Development Facilitation Team (DFT) – Review Comments

Project No: PR-2021-005461 Date: 01/10/2024 Agenda Item:3 Zone Atlas Page: H-20

Application For: SD – 2024-00002 – PRELIMINARY/FINAL PLAT

Application For: VA – 2024-00001 – WAIVER TO IDO (SIDEWALK)

Plat of  
 Parcels 5-A-1 and 5-A-2  
**Wyoming Mall**  
 Section 8, Township 10 North, Range 4 East, N.M.P.M.  
 Albuquerque, Bernalillo County, New Mexico  
 April 2023

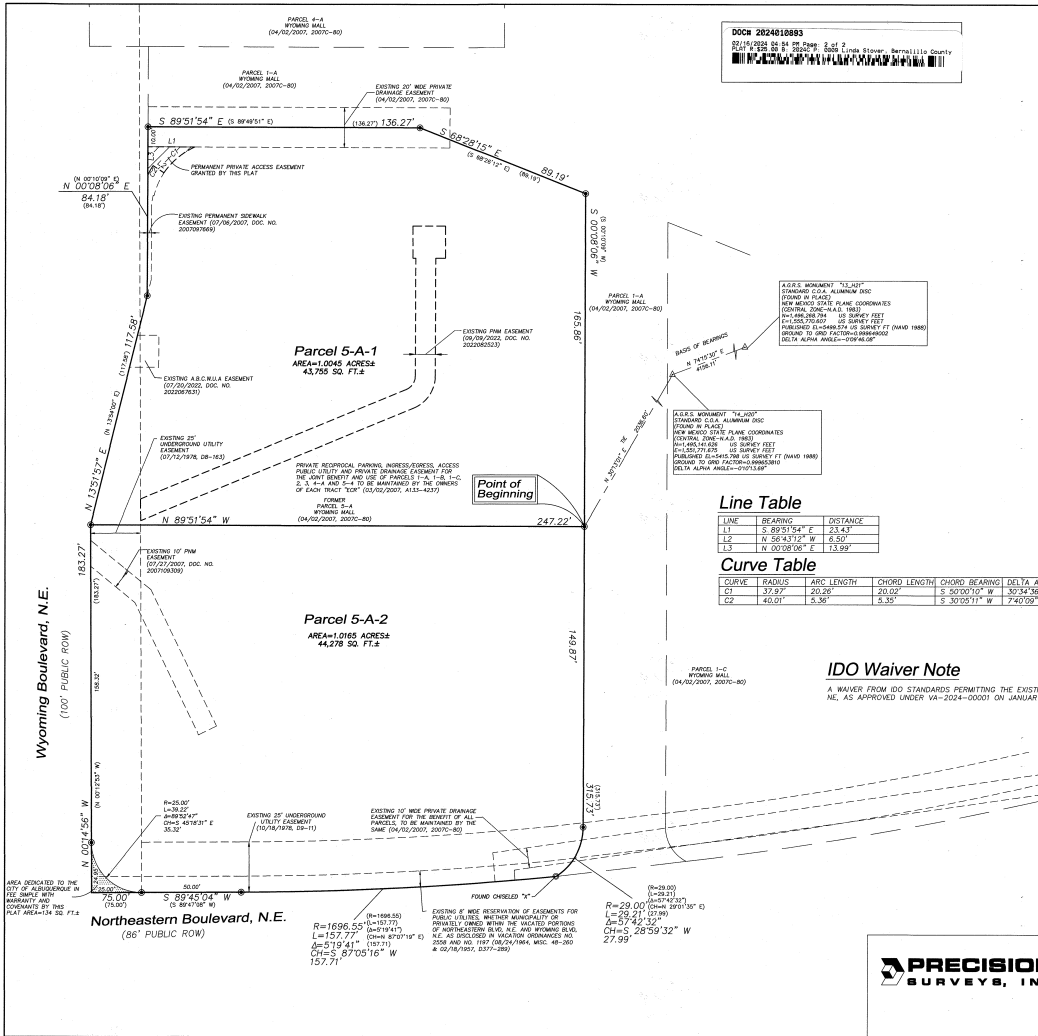
- Please clarify if the proposed replat will be affecting any existing easements. Marked in orange on the image below:

MATCHLINE
SEE SHEET 2

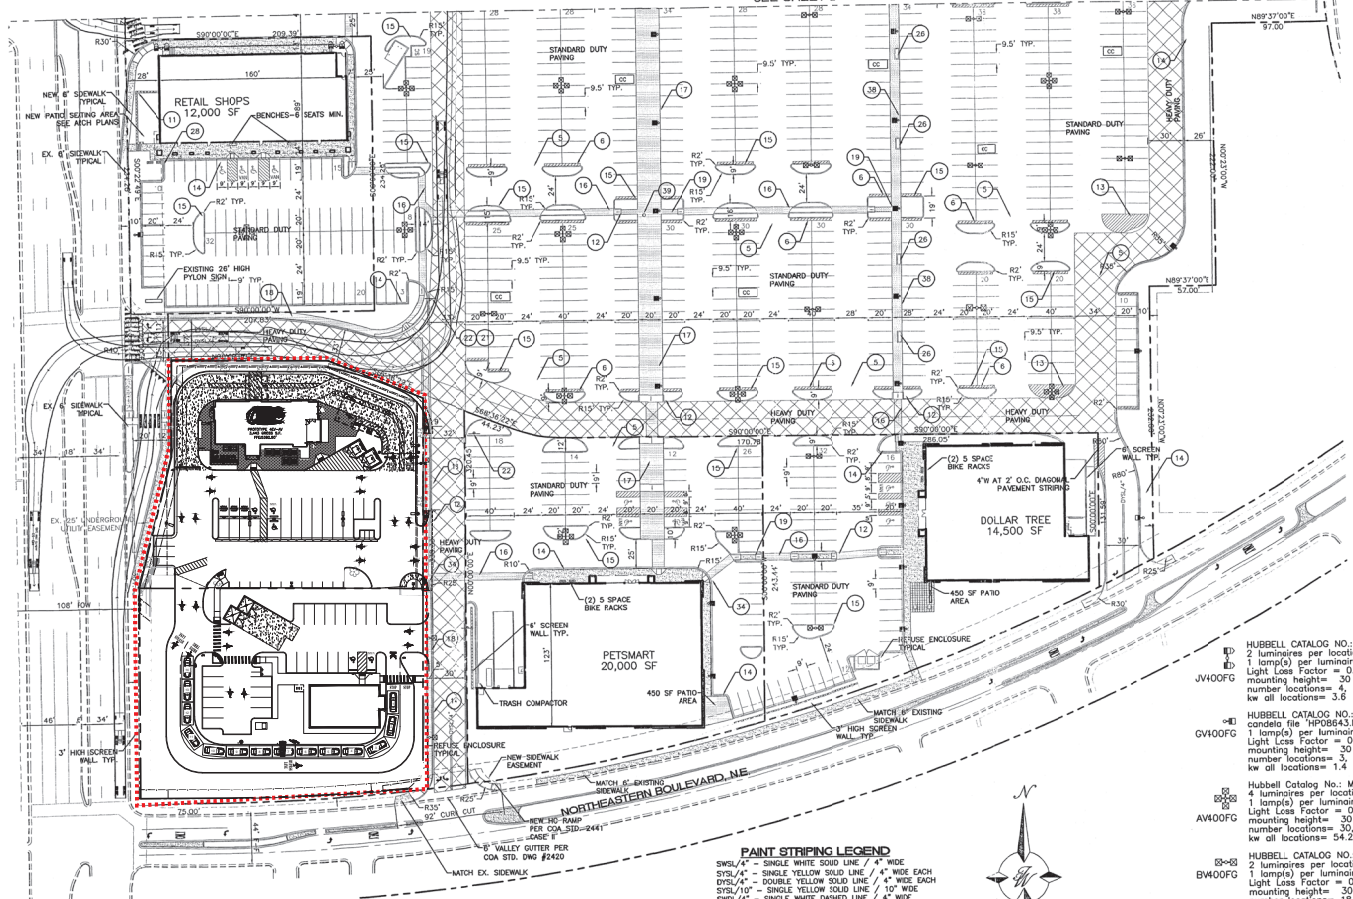
1. Need to have the cross-lot access noted as shown on site plan SP-1.
2. Code Enforcement has no further comments or objections to the proposed re-plat and waiver.
